From: Sue Howell <Sue.Howell@arun.gov.uk>
Sent: 26 May 2021 18:02
To: Planning.Responses <Planning.Responses@arun.gov.uk>
Cc: Simon Davis <Simon.Davis@arun.gov.uk>
Subject: FW: Planning Consultation on: AL/49/21/DOC

Application ref: AL/49/21/DOC

Description: Approval of details reserved by condition imposed under ref AL/64/20/PL relating to Condition Nos 5 - pre-commencement site meeting with Tree Officer, 6 - mitigation method statement, 7 - archaeology, 8 - Construction & Environmental Management Plan, 13 - detailed level survey, 14 - materials & finishes, 15 - details of all new screen walls & fences, 16 - landscaping, 18 - energy efficiency measures, 19 - covered & secure cycle parking spaces, 21 - broadband, 22 - charging of electric vehicles and 25 external lighting.

Location: Springfield Hook Lane Aldingbourne PO20 3TE

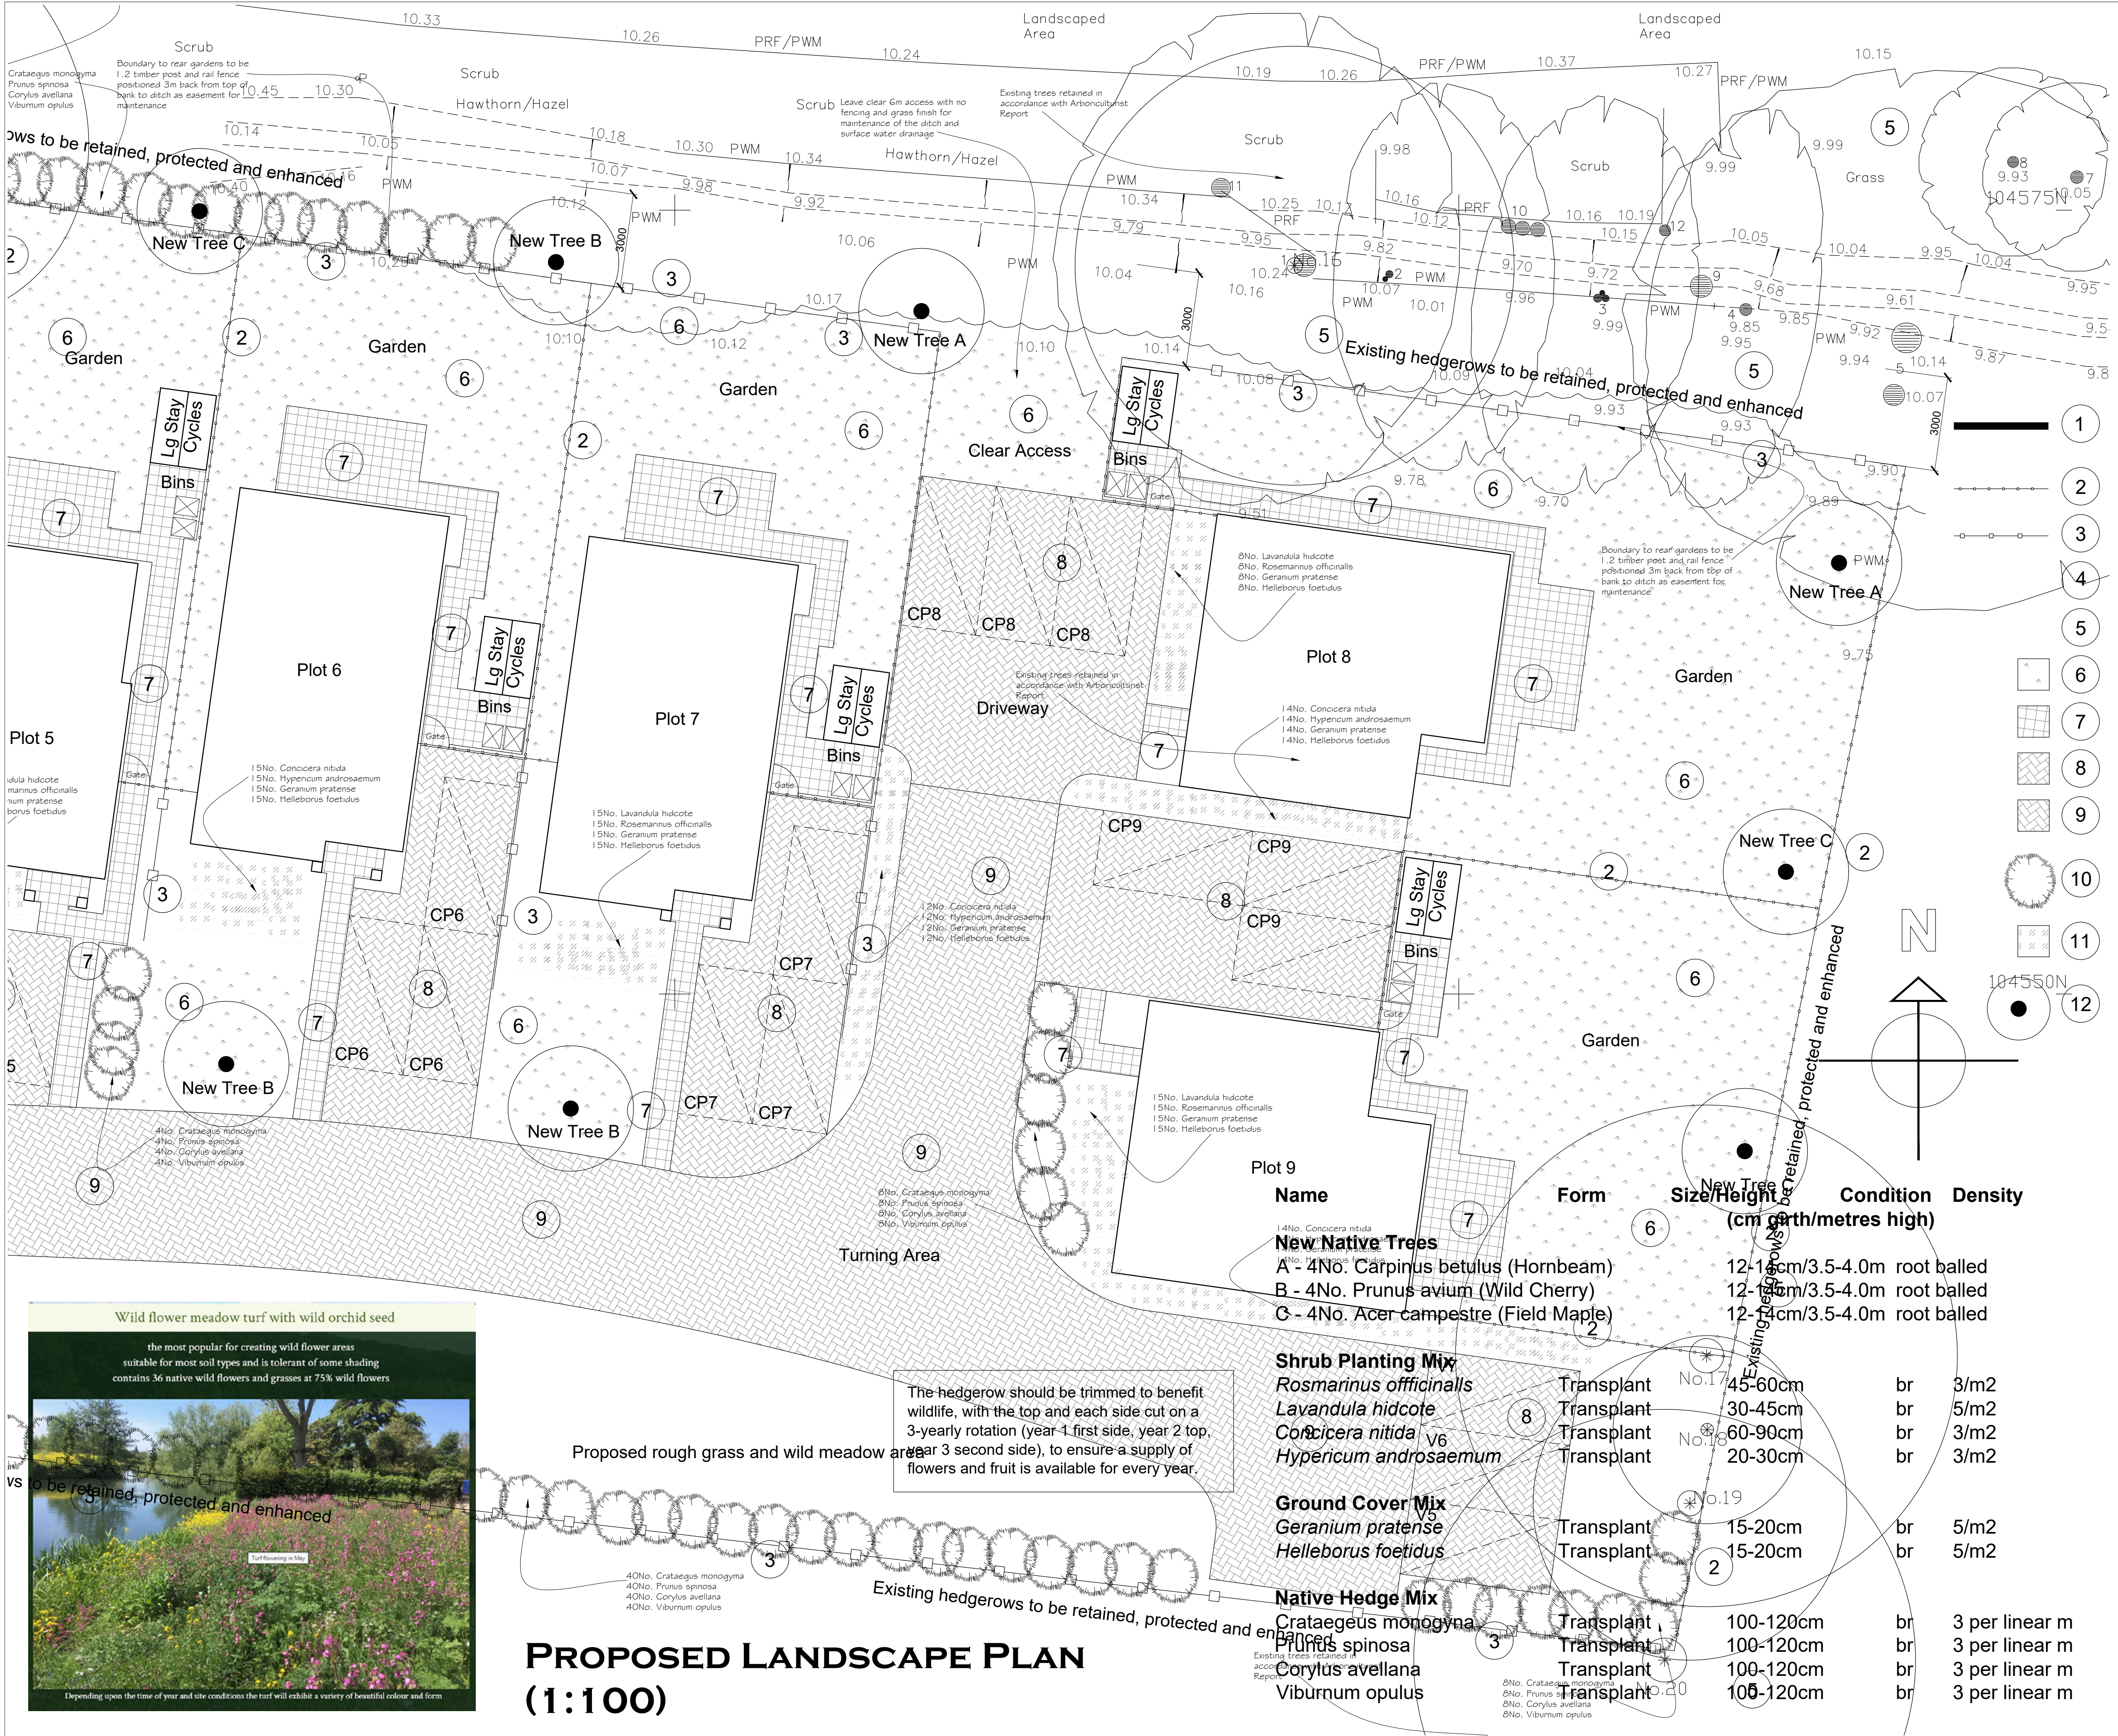
The submitted drawings re landscape Condition 16 have shown a scheme which would be suitable for location (assuming no drainage conflict) with species choice and densities shown. However actual quantities for the shrubs and hedges need to be shown also on these plans: Proposed Landscape Plan Dwg 13 and Dwg 14.

Recommend that the actual quantities of the shrubs and hedging proposed are required to be shown on the above plans before discharge of Condition 16 on application AL/49/21/DOC imposed under ref AL/64/20/PL can be made.
